From: Grant Morrison <grant@inspectionsplusinc.com>
Sent: Friday, May 13, 2016 2:34 PM
To: Cherne, Curtis
Subject: RE: BHI parking lot repave ESC plan question

From: Cherne, Curtis [<mailto:CCherne@cabq.gov>]
Sent: Friday, May 13, 2016 2:25 PM
To: 'grant@inspectionsplusinc.com' <grant@inspectionsplusinc.com>
Subject: BHI parking lot repave ESC plan question

Erosion Sediment Control Plan

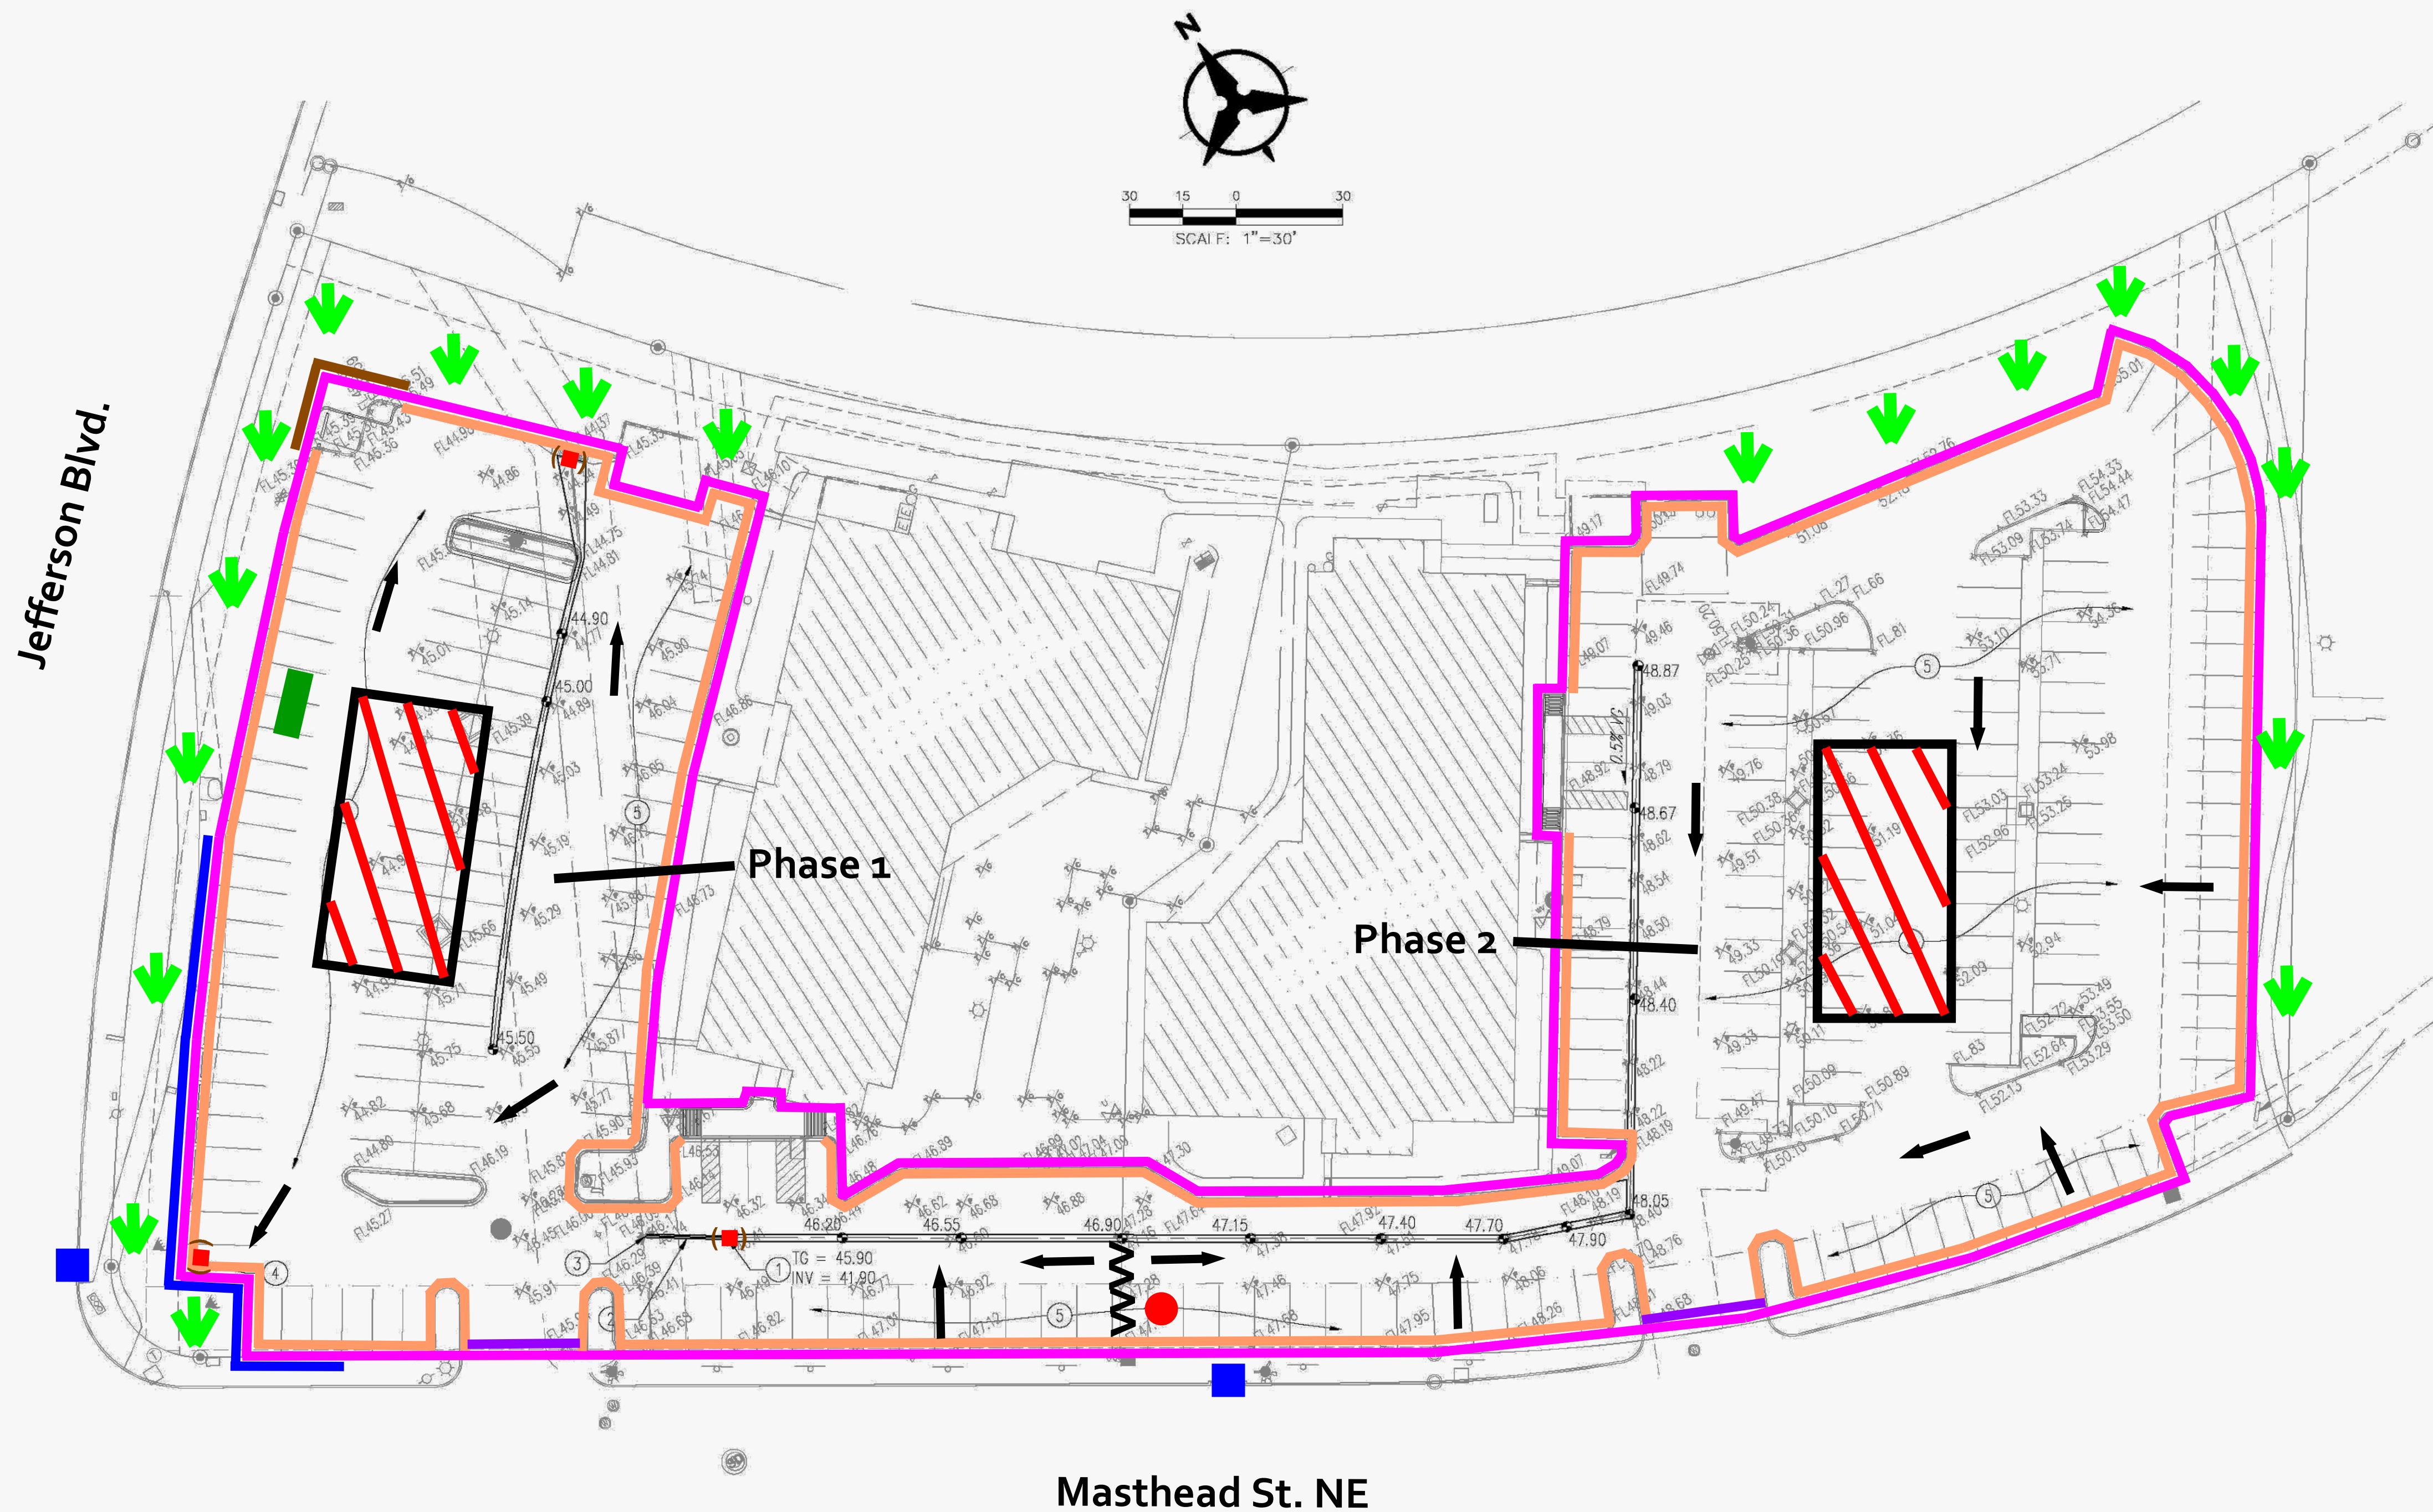
I've reviewed the plan and have a question concerning no track-out pad.

During Phase 1 the contractor(s) can drive through Phase 2. It seems like a long enough distance to effectively work for track-out.

However, I don't see how it will work during Phase 2. BHI will not want the contractor to drive on the new asphalt. I saw the note that it will be swept each day. I like that. However, if the dirt gets wet, the track-out could get away from them without a track-out pad.

Please justify why you feel a track-out pad should not be in place for Phase 2.

This project will be done in 30 days. The contractor will use the phase 1 parking lot to enter Phase 2 because once the asphalt is demo'd they are grading and right back with base course so the trackout would interfere with construction on both phases. Hence the street sweeping to manage trackout
